Subject: A/31/19/PL.

I am surprised the application is not being assessed pursuant to the granting of A/212/17/PL, which benefits from 2 Extant Plots (8 and 9) and which defines the Extent of Use and The First Schedule, and come under reserved matters. A/87/18/PL is one large plot and half of A/176/17/PL, both of which were refused by Arun, and A/176/17/PL was also dismissed at appeal. The lower part of A/87/18/PL is covered by A/212/17/CLP and A/212/17/CLP covers both A/31/19/PL and the remaining extant plot which is material in this matter.

A/31/19/PL proposes one large dwelling on Plot 9 which is a similar property to that on A/87/18/PL but on a smaller plot. A/87/18/PL was refused under policies D DM1, OSR DM1 and HD5.

Drawing Title:
Proposed Plans, Elevations and Street
Scene Elevation
Drawing Number: 1202.01.c
Scale: As stated printed @ A1
Date: 06/02/2019

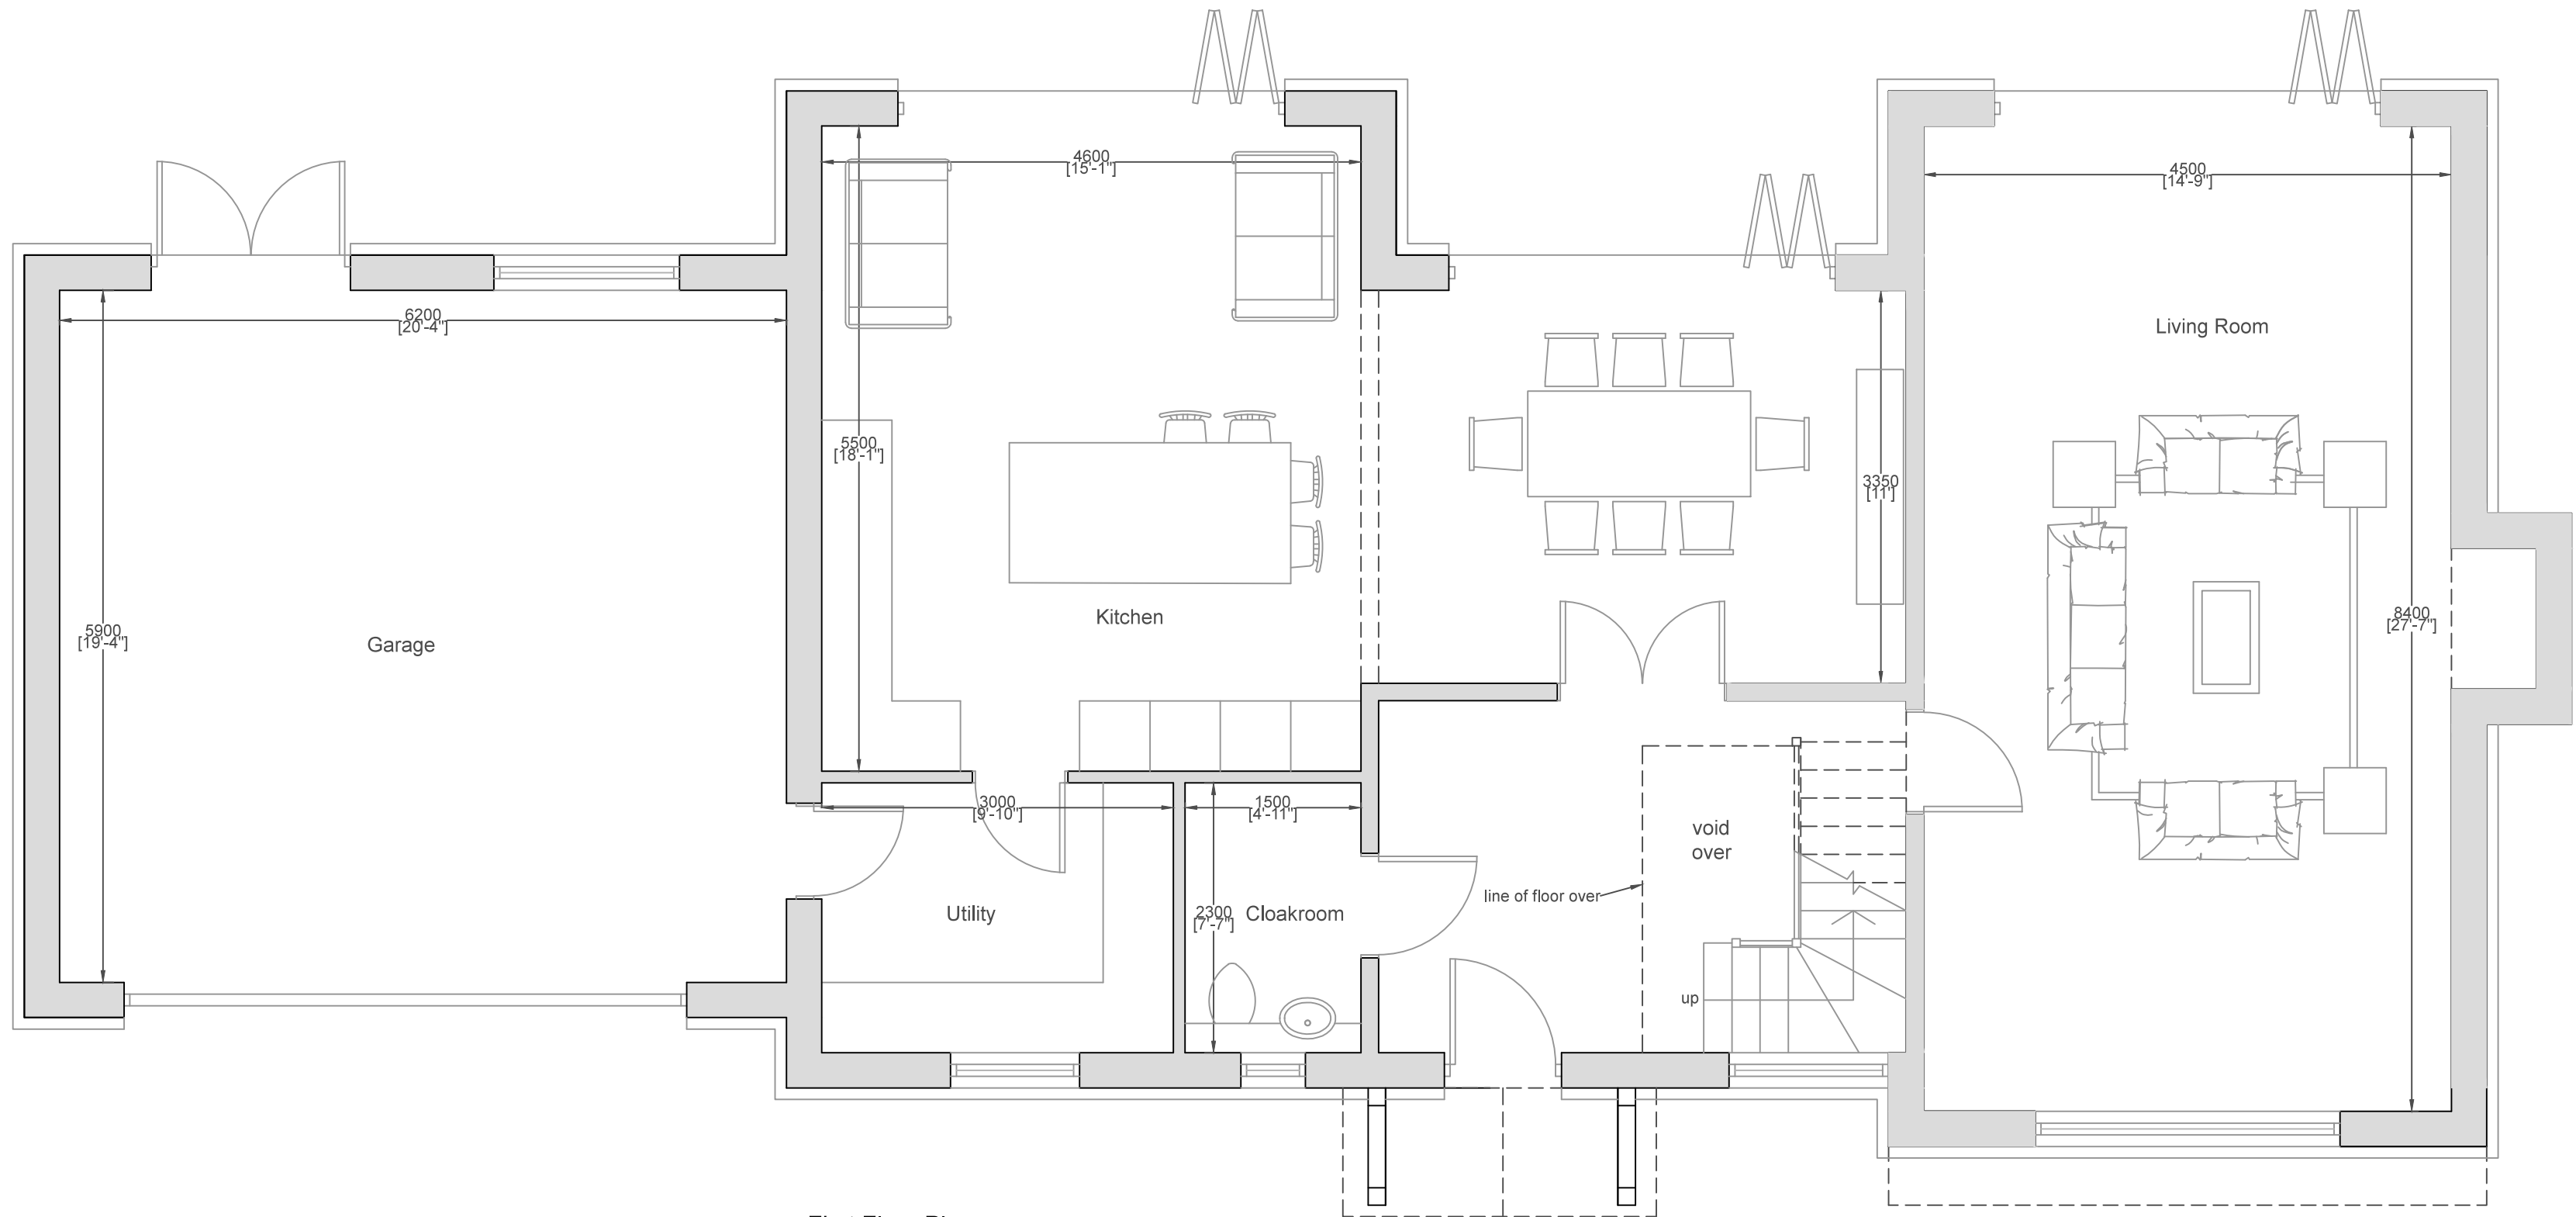
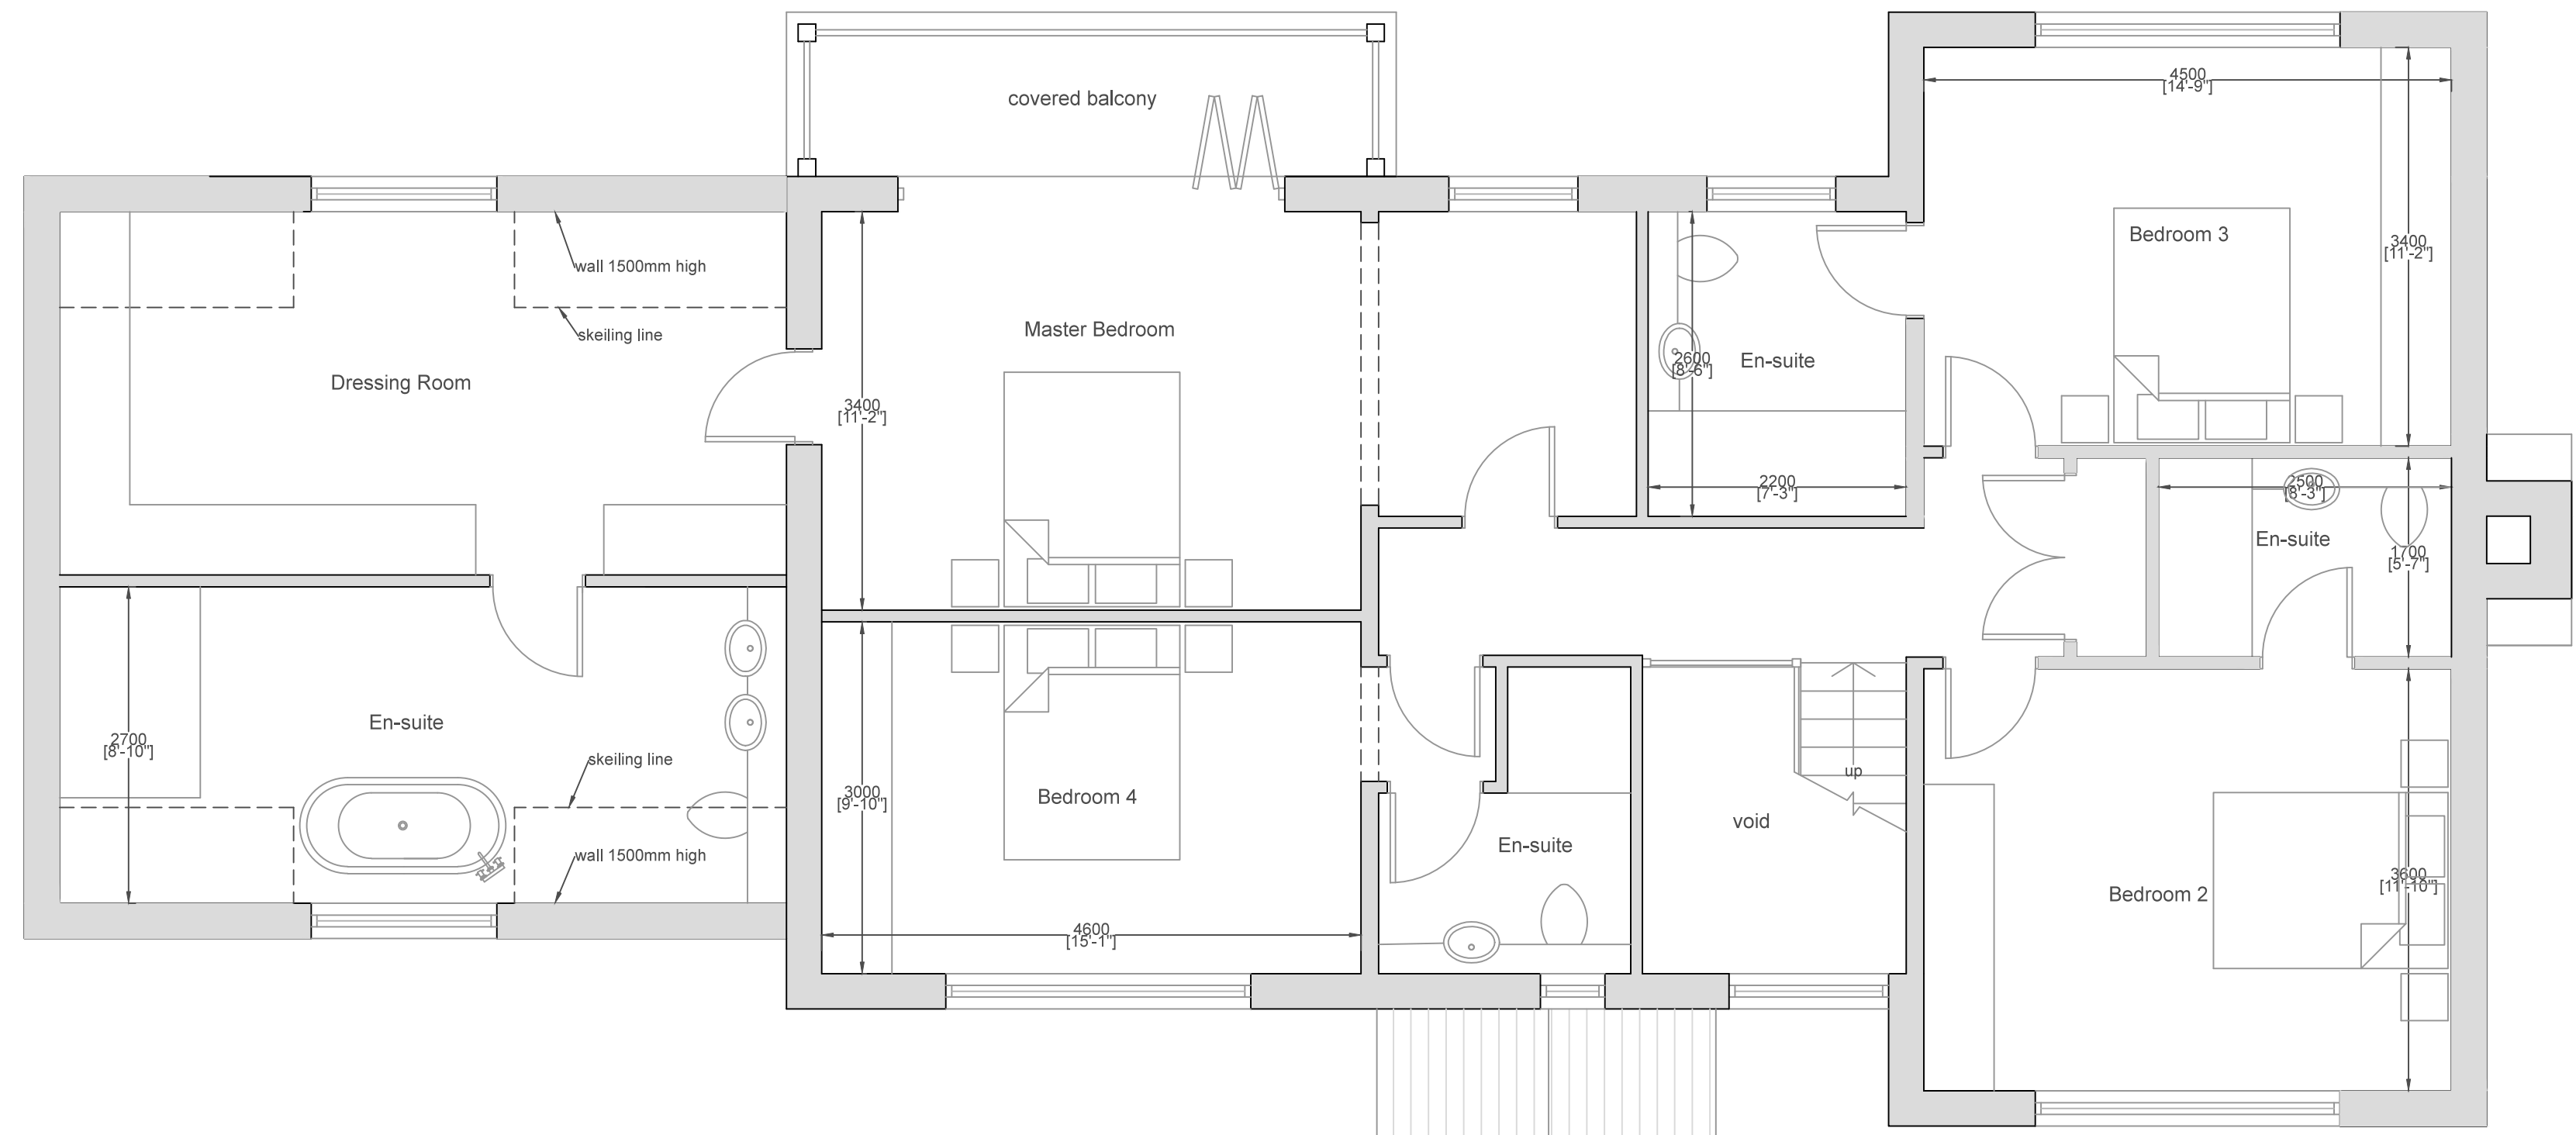
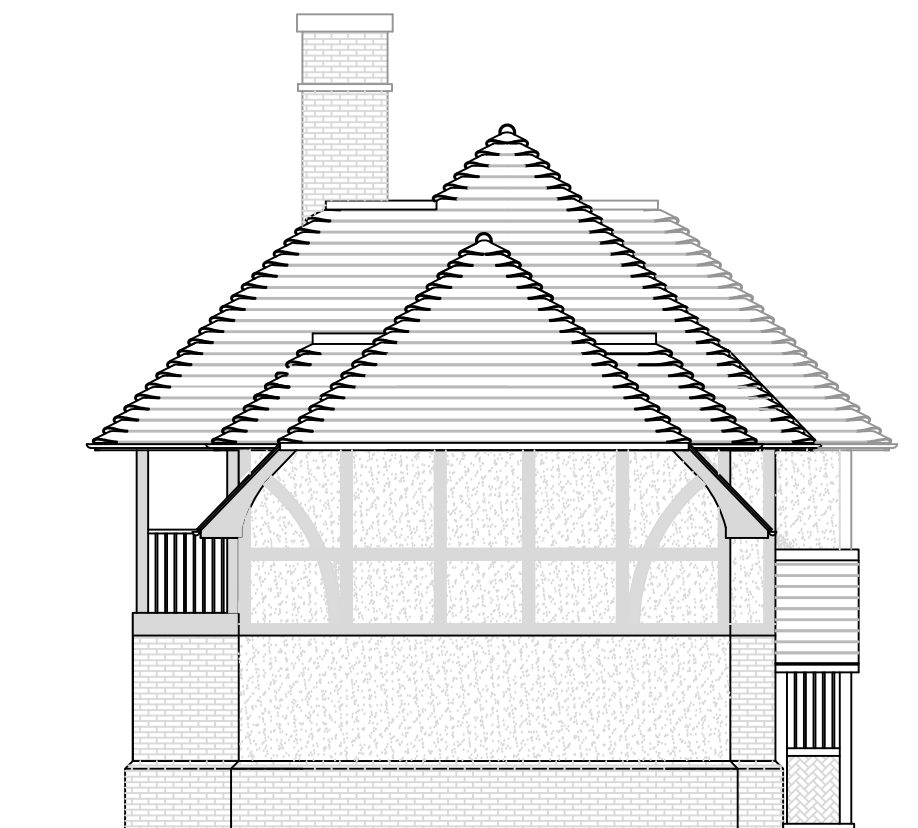
There are no windows on the South aspect which infers forward planning for privacy when Plot 8 is developed. As the proposal virtually occupies all of Plot 9 then when Plot 8 is developed there will be a "wall" of property. The dwelling on Plot 9 itself is against policy with regard to affecting the character of the area but it and Plot 8 will be totally against the Inspector's description and vision of a verdant area with generous spacings between dwellings. The proposed dwelling is significantly higher than Ashurst (although the documentation states the contrary) and the other surrounding bungalows and will appear overwhelming, unharmonious and exceptional in its position.

HD 4. There is a contradiction in the documentation as to whether the first floor is timber/render or timber inserts. Neither however are harmonious with the surrounding properties.

Street Elevation (1:200)

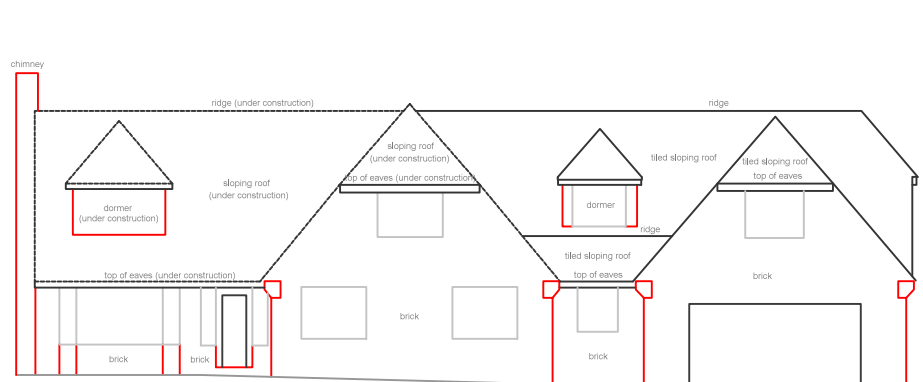
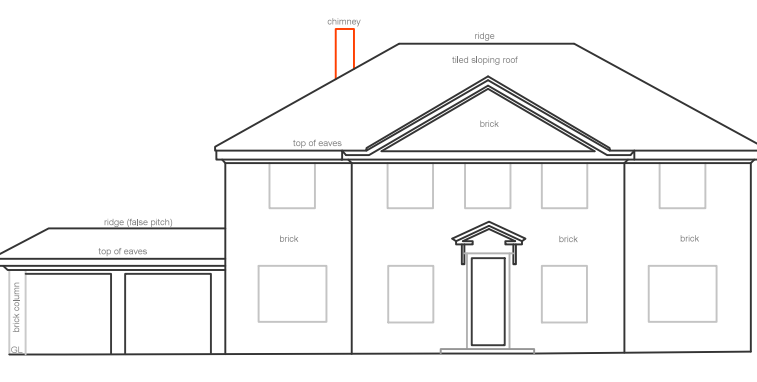
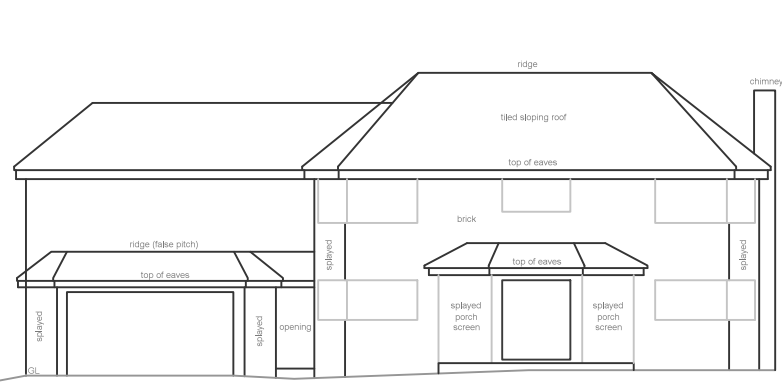
The proposed dwelling will be a large imposing property out of character with the area. The proposed dwelling is surrounded by bungalows or protected green space and not as stated in the application as being surrounded by substantial properties nor is it an area characterised by large 2 storey houses. Immediately to the South are two bungalows and four further South. To the East and opposite are eight bungalows. To the North there is protected green space and a high hedge hiding much of Badgers. To the West is protected green space. Notably the Inspector dismissed the A/176/17/PL appeal on the property affecting the character of the area.

The proposed dwelling sits much closer to the road than other properties and therefore has a greater impact. It also appears to be in front of the established build line. It should also be noted that the Inspector refers to properties being a comfortable distance from the road.
